Lead Member of the Examining Authority
North Falls Offshore Windfarm DCO
National Infrastructure Planning
Template Quay House
2 The Square, Bristol
BS1 6PN

Our Ref: 20048269
PINS Ref: EN010119
Date: 1818 March 2025
Telephone: 03330 322546

Planning Act 2008 – Application by North Falls Offshore Wind Farm Limited for an Order Granting Development Consent for the North Falls Offshore Windfarm (EN010119)

I refer to the Rule 8 letter dated 4 February 2025 which sets out the Examination Timetable for the above Development Consent Order (DCO), currently at Examination. Essex County Council (ECC) in conjunction with Tendring District Council (TDC), and as described as The Councils, would like to respond to provide a written response to the Applicant's submission at Deadline 02.

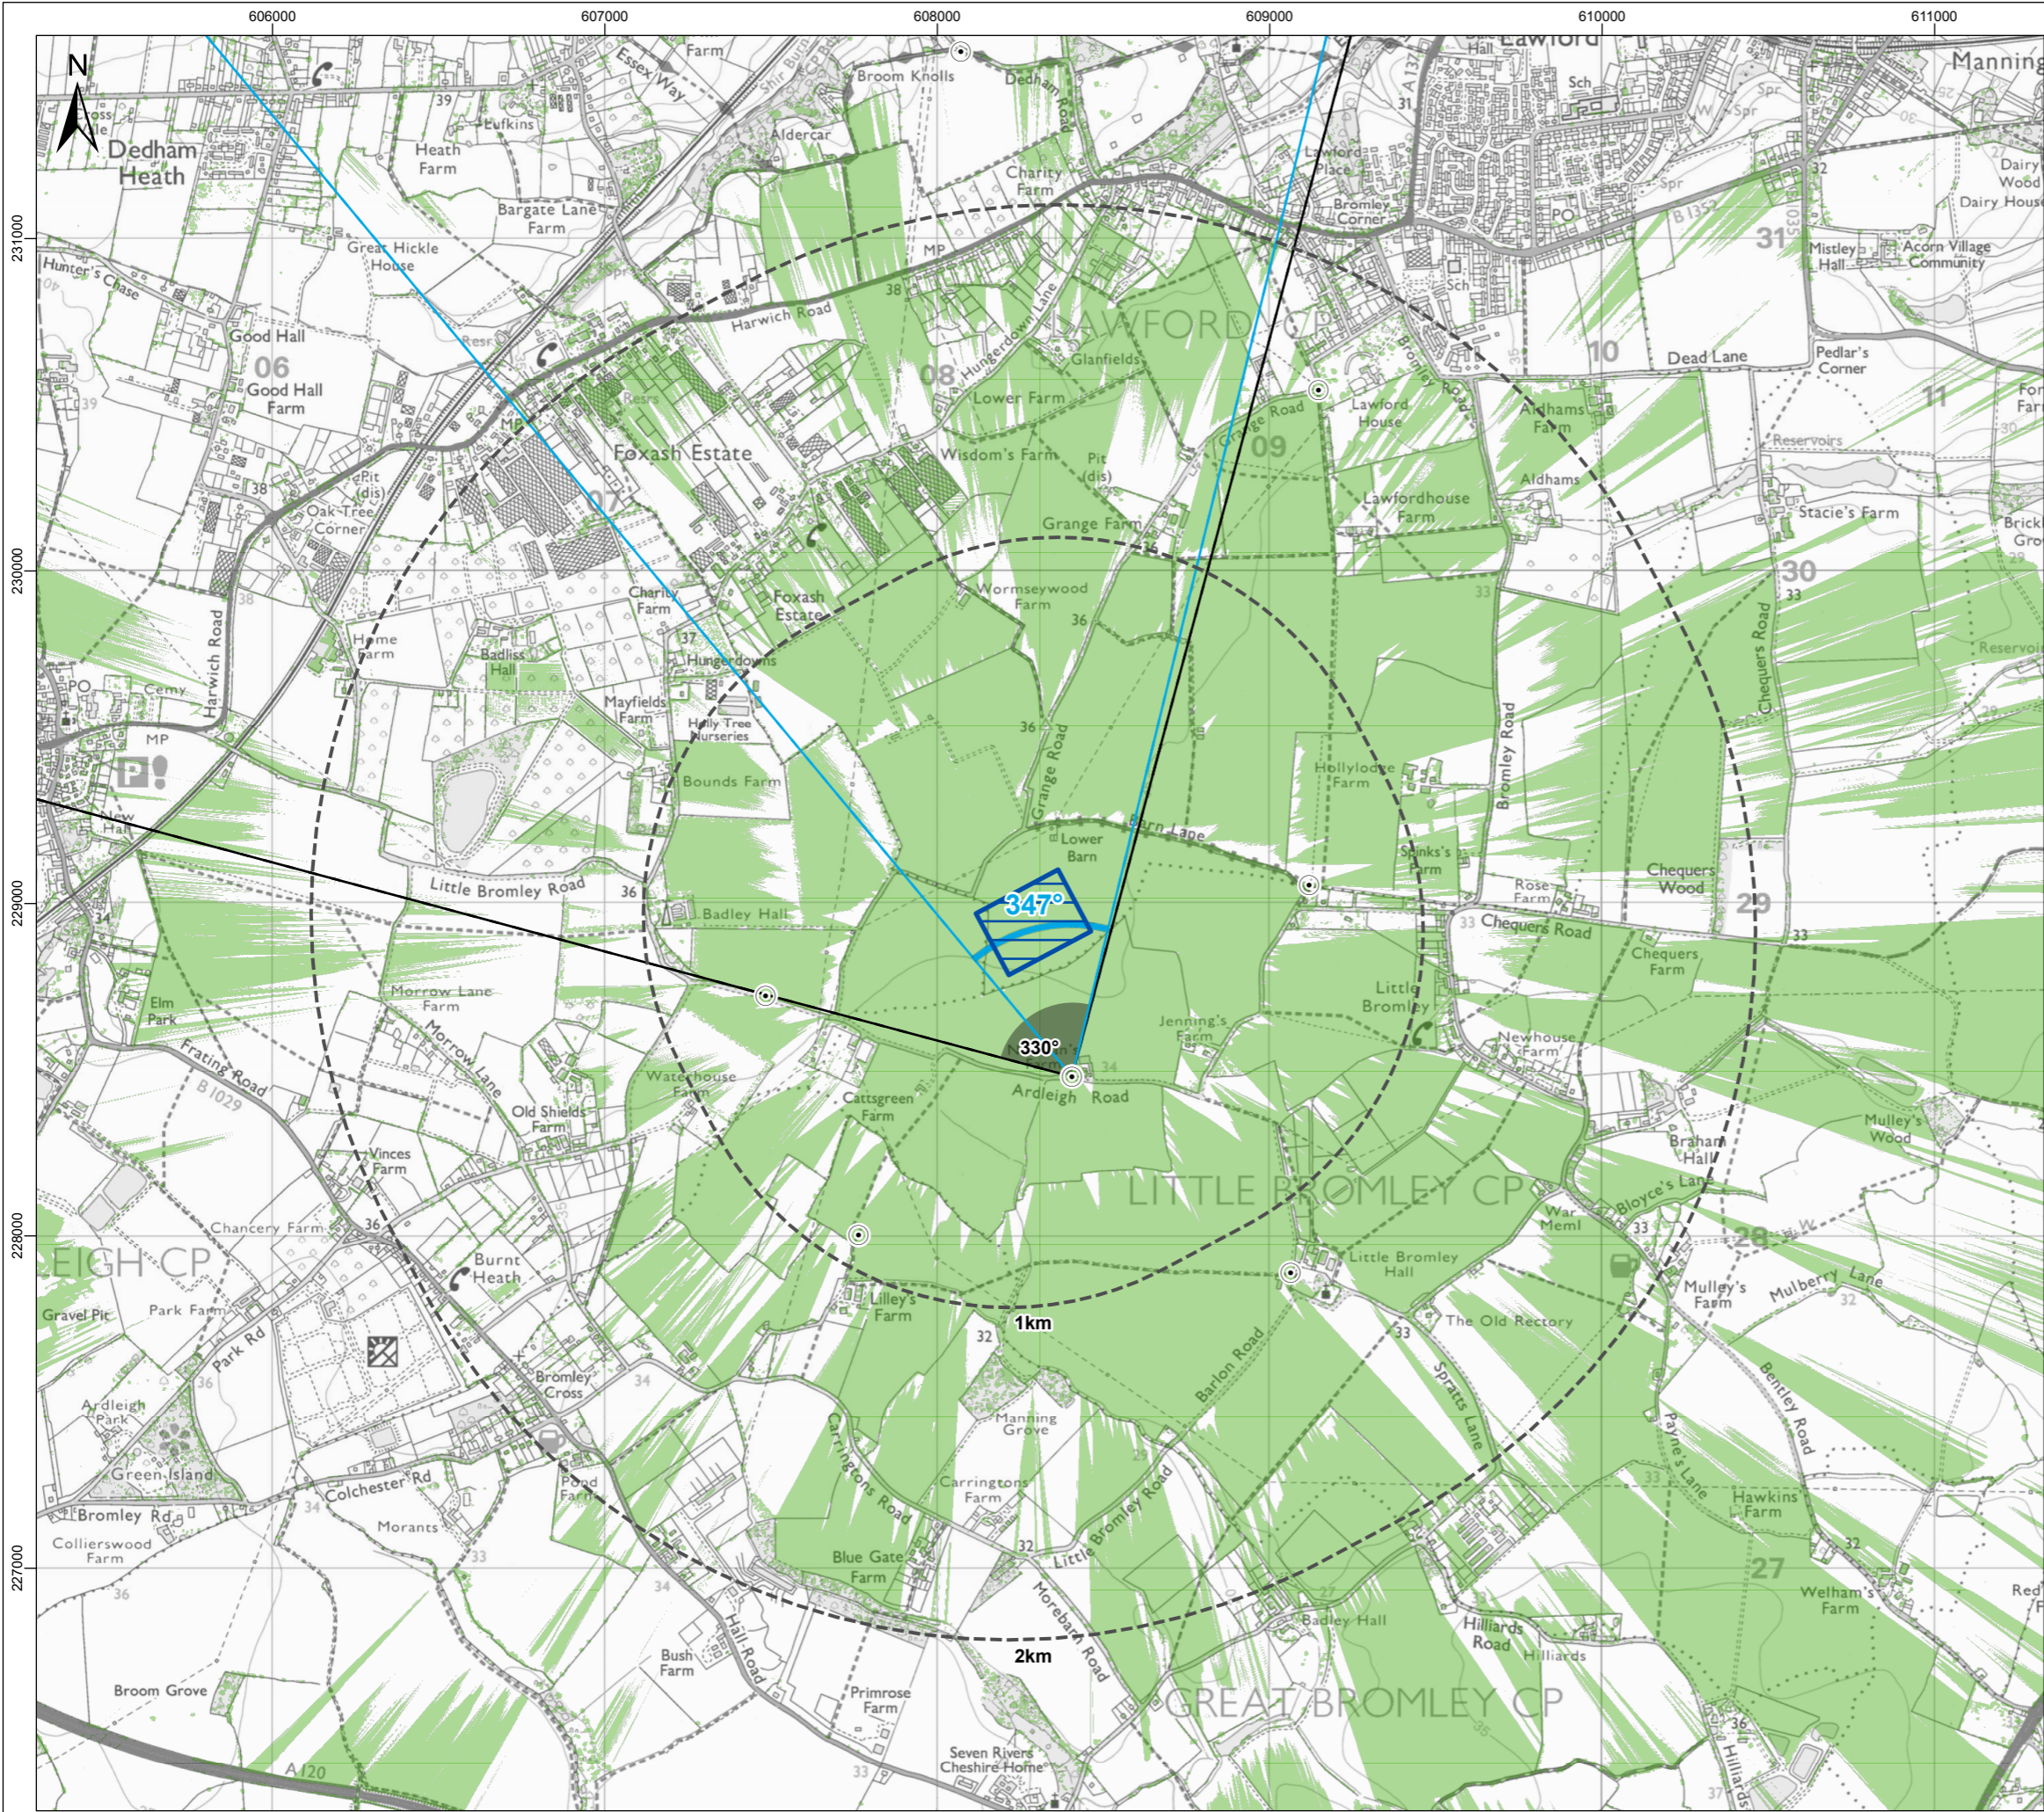
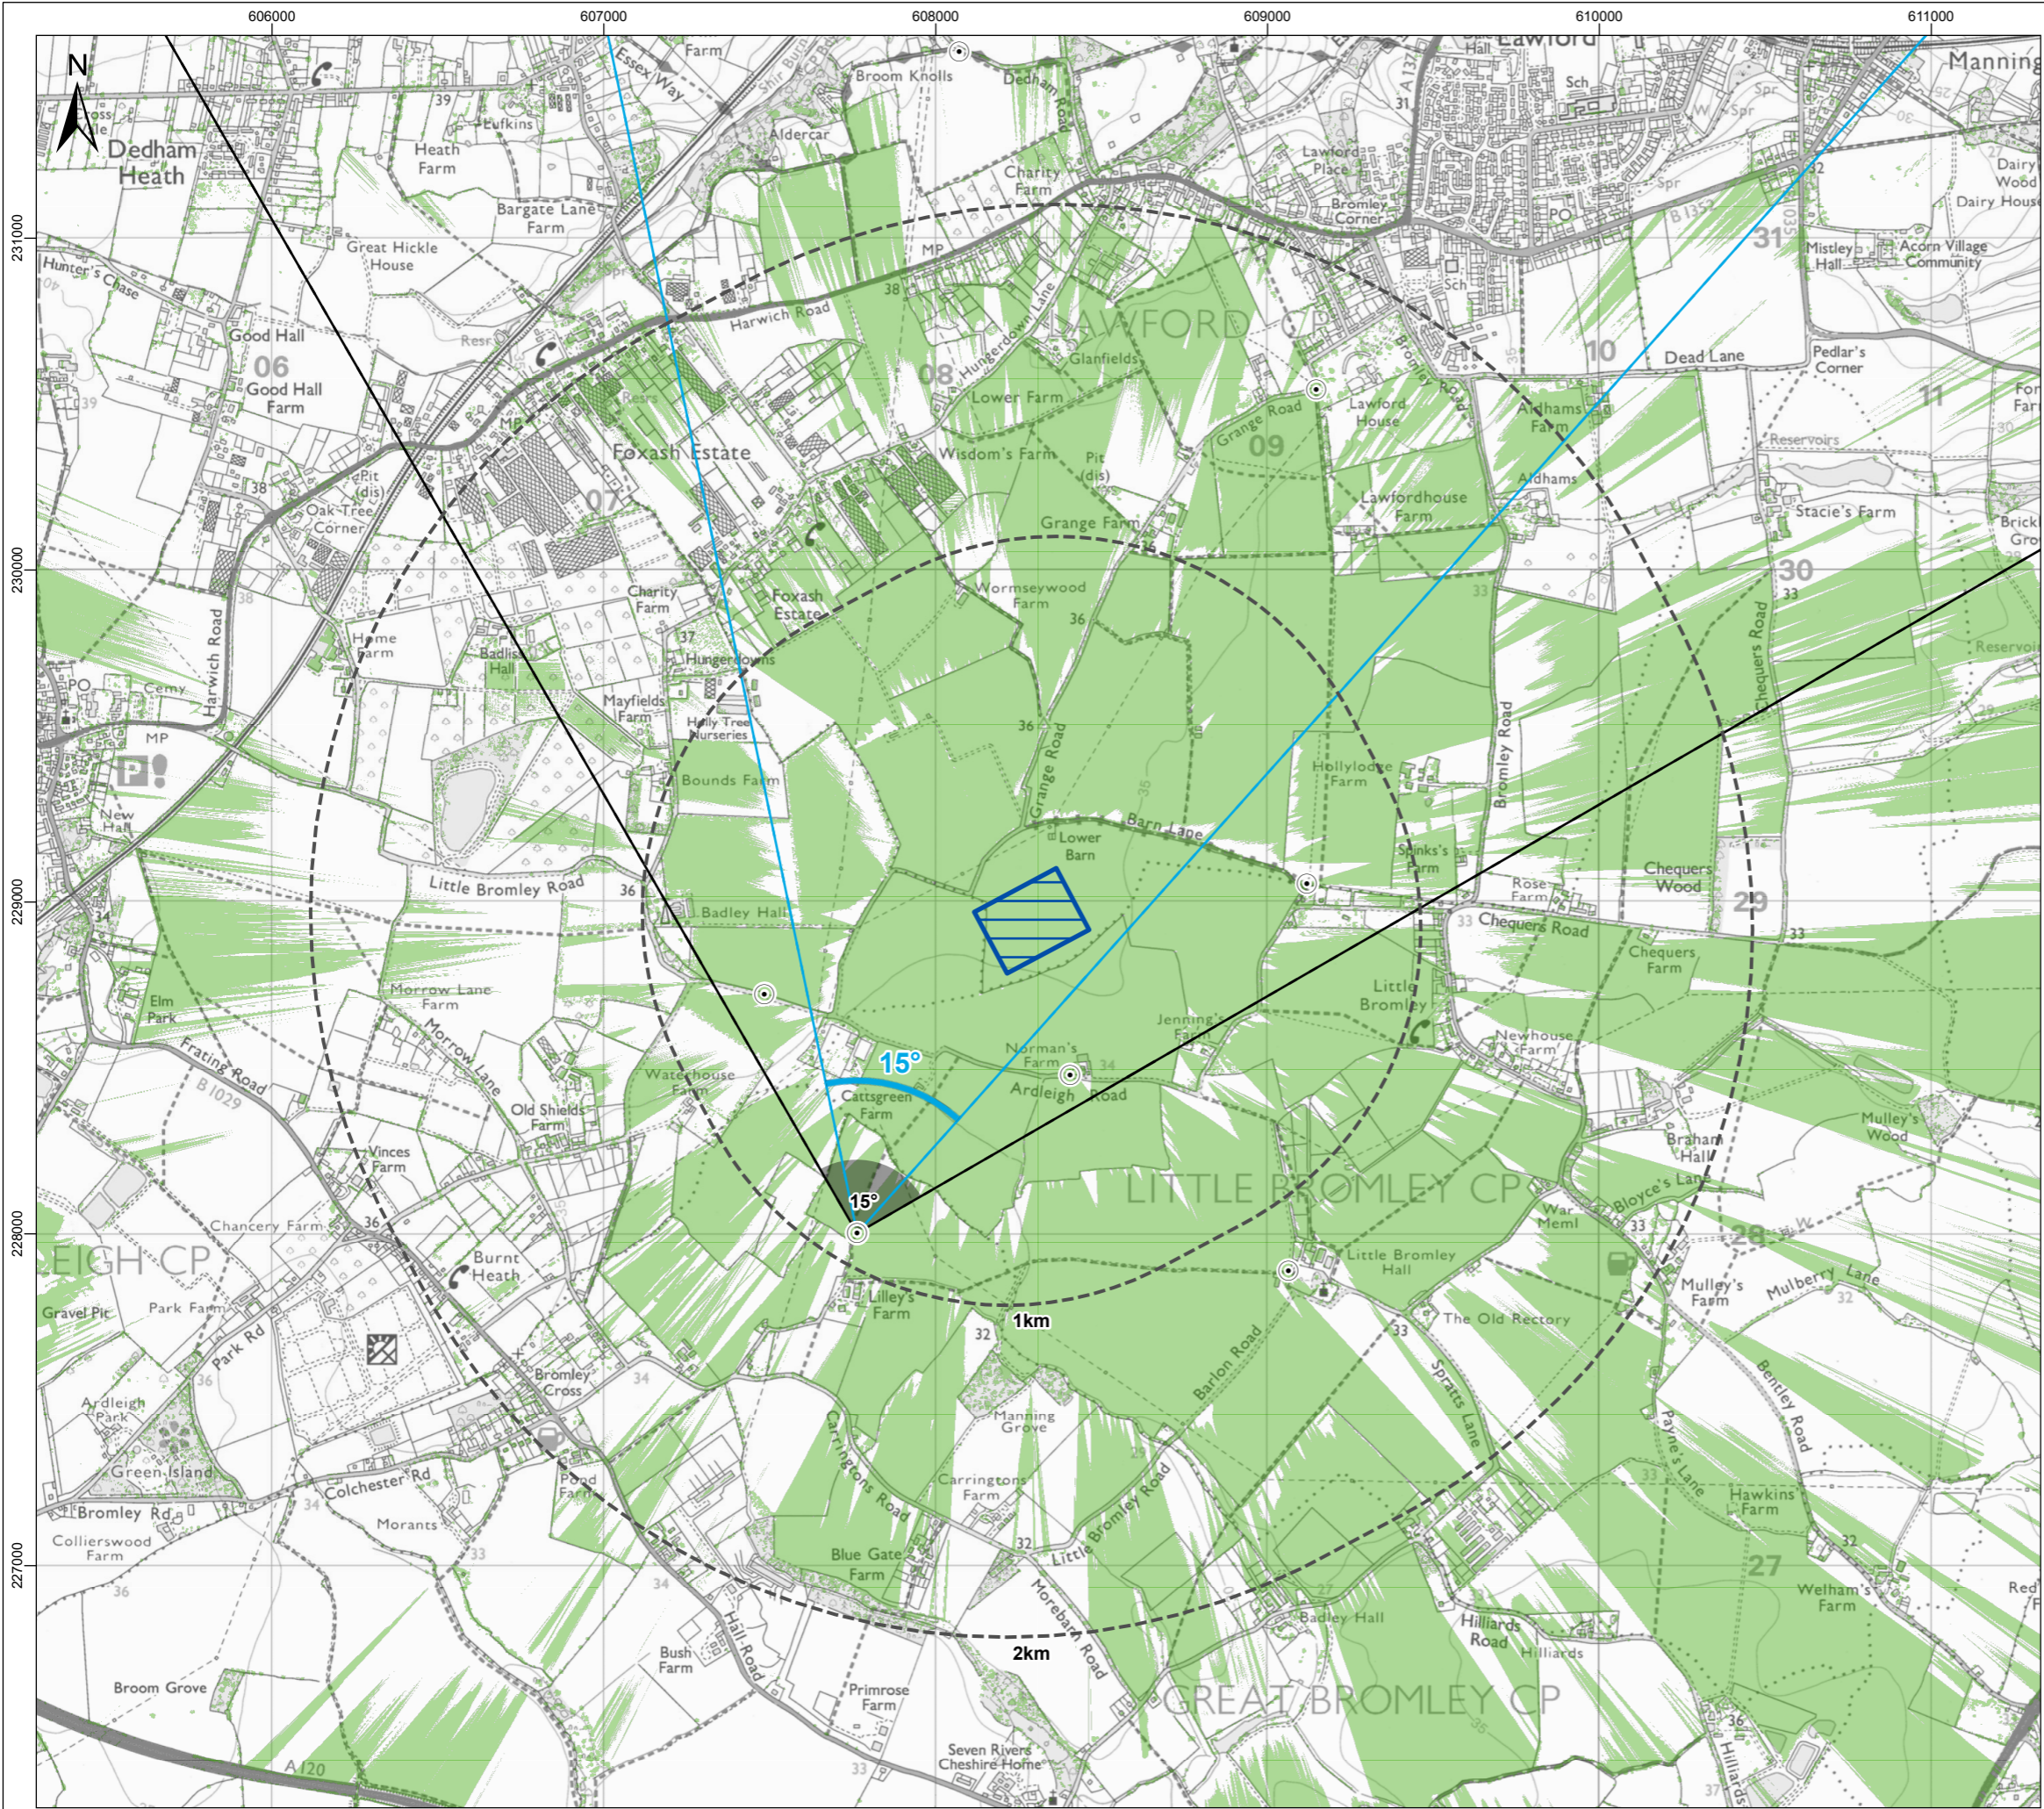
The cumulative visualisations [APP-084 to APP-088], do not demonstrably include the overhead power lines for the Norwich to Tilbury project which would connect into EACN. Therefore, we do not agree that a demonstrably meaningful cumulative assessment has taken place.
